Current Zoning: B-D (CD) AIR (distributive business, conditional, airport noise overlay)  
Proposed Zoning: I-1 (CD) AIR (light industrial, conditional, airport noise overlay)

Approximately 105 acres located between Shopton Road and Beam Road.

The petition proposes to permit the development of a vacant parcel with up to 1,250,000 square feet of gross floor area of warehousing, warehouse distribution, manufacturing, office, and industrial uses.

Staff recommends approval of this petition upon resolution of outstanding issues related to transportation, and technical revisions related to transportation and site and building design.

## SITE PLAN

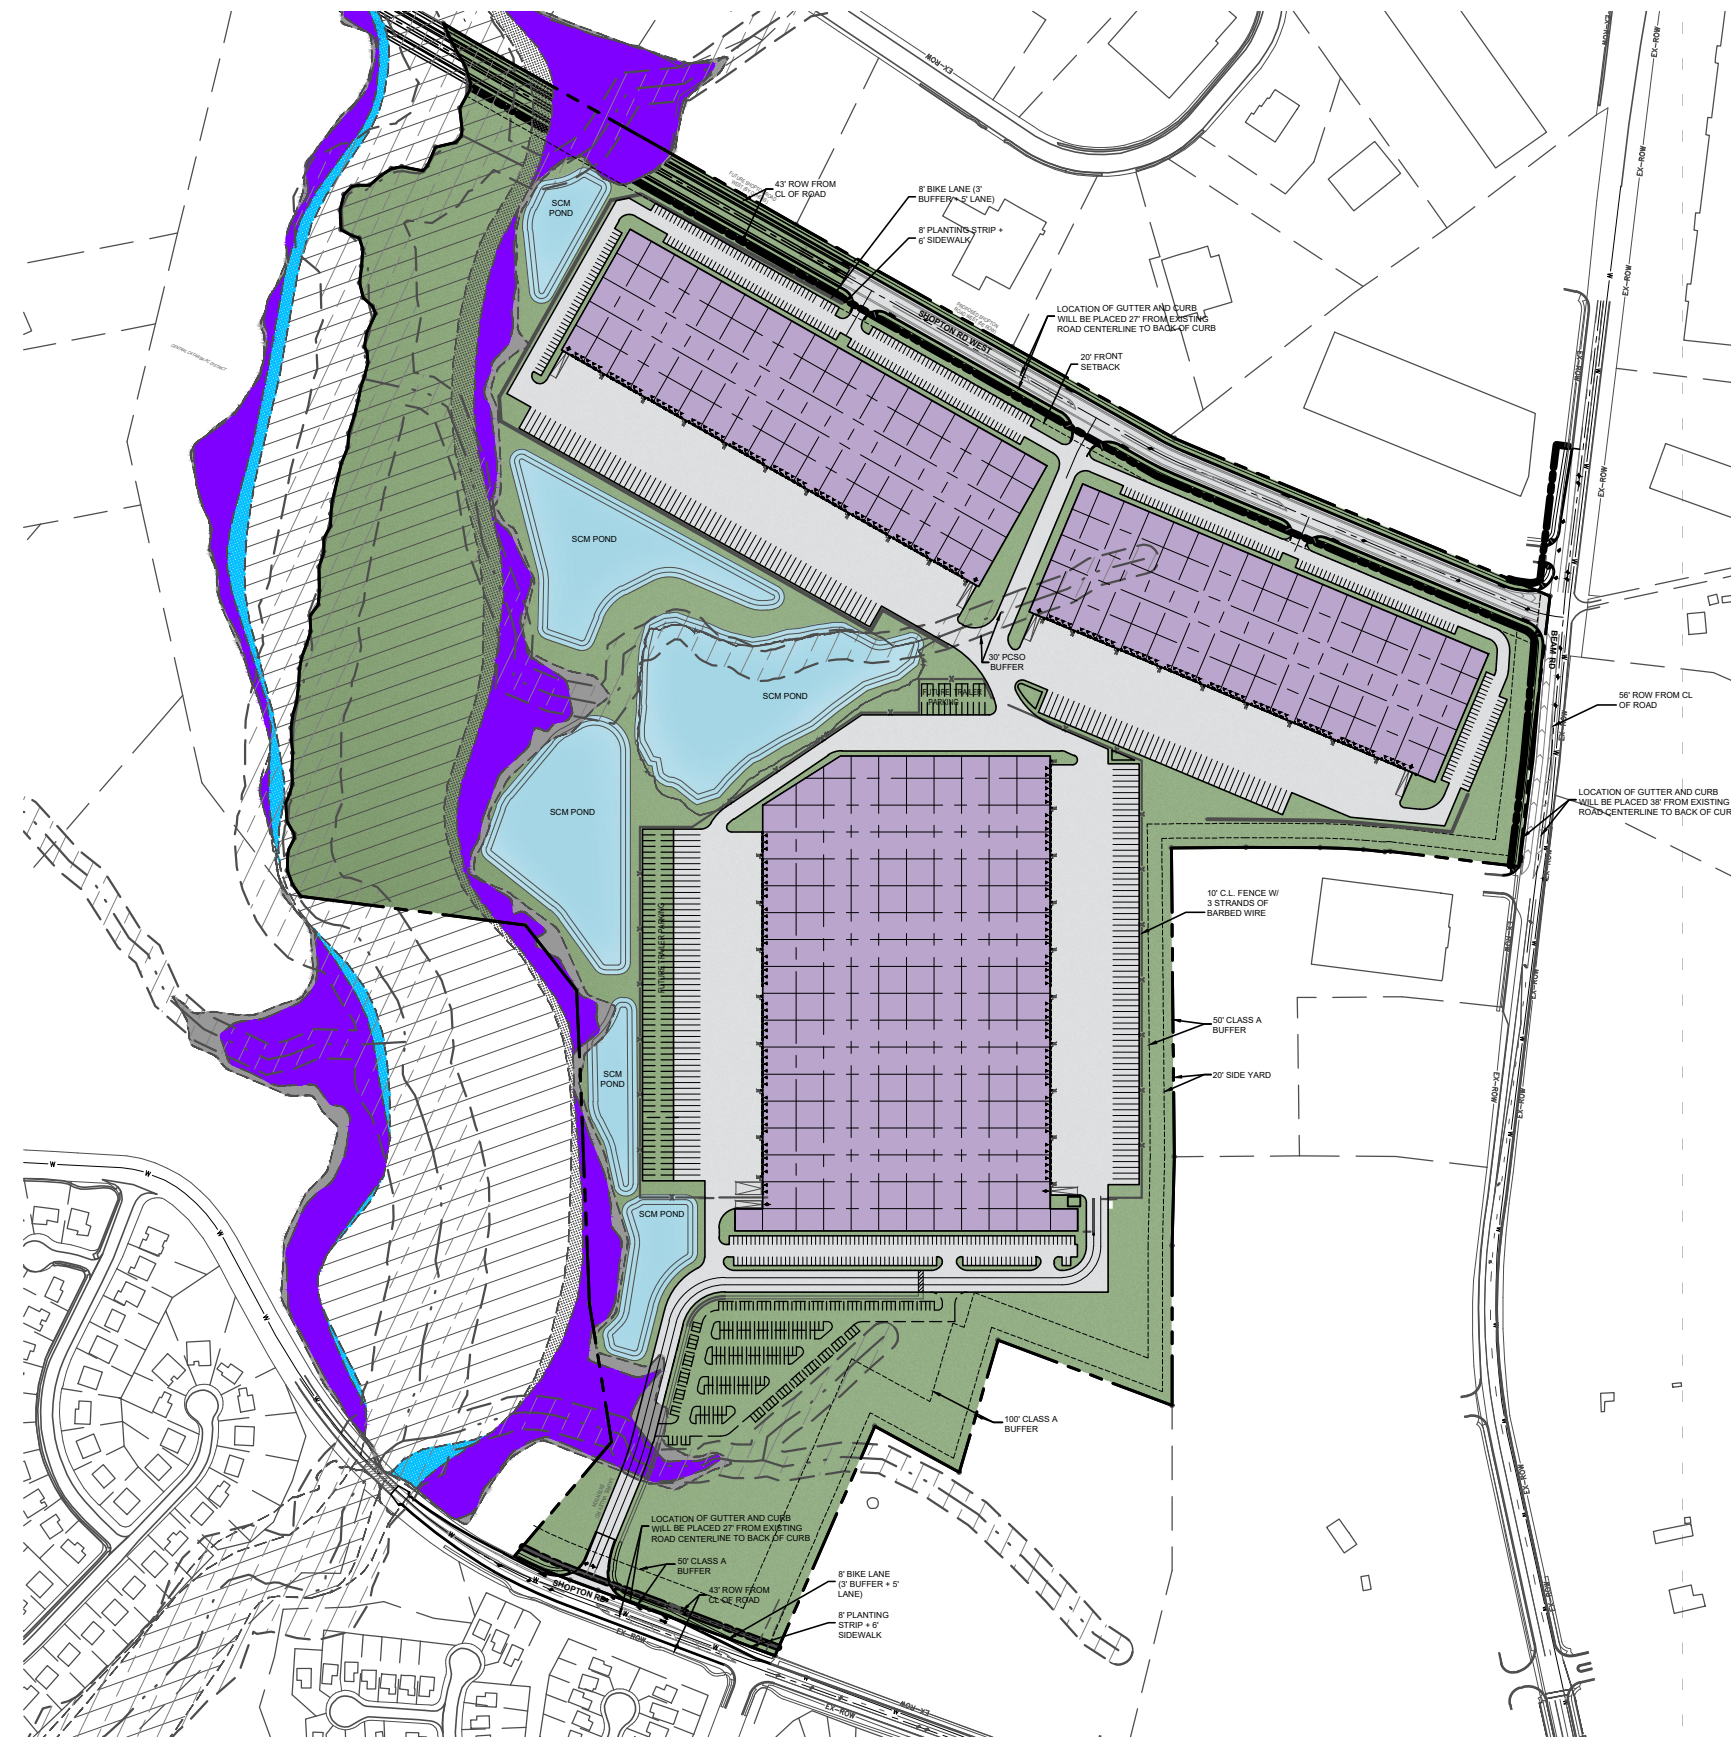
1. Revise the site plan and conditional notes by committing to dedicate the right-of-way for the future segment the Shopton Road Extension, that will not be constructed with this development, to CDOT. The amount of right-of-way dedication should be proportionate with the cross section established in Note 10 of this memo. Label the total width associated with right-of-way dedication associated with the Shopton Road Extension.

2. Revise conditional note III.i by modifying the phasing of the Beam Road transportation improvements. All the transportation improvements on Beam Road shall be completed prior to the Shopton Road Extension is connected to Beam Road.

3. Remove the "+/-" from the building area square footage on site plan notes.
4. Depict and label the buffer adjacent to Beam Road as 50' Class A. Correct corresponding note V.b.
5. Depict and label the buffers along the eastern and southeastern property boundaries as 100' Class A. Correct corresponding note V.a.
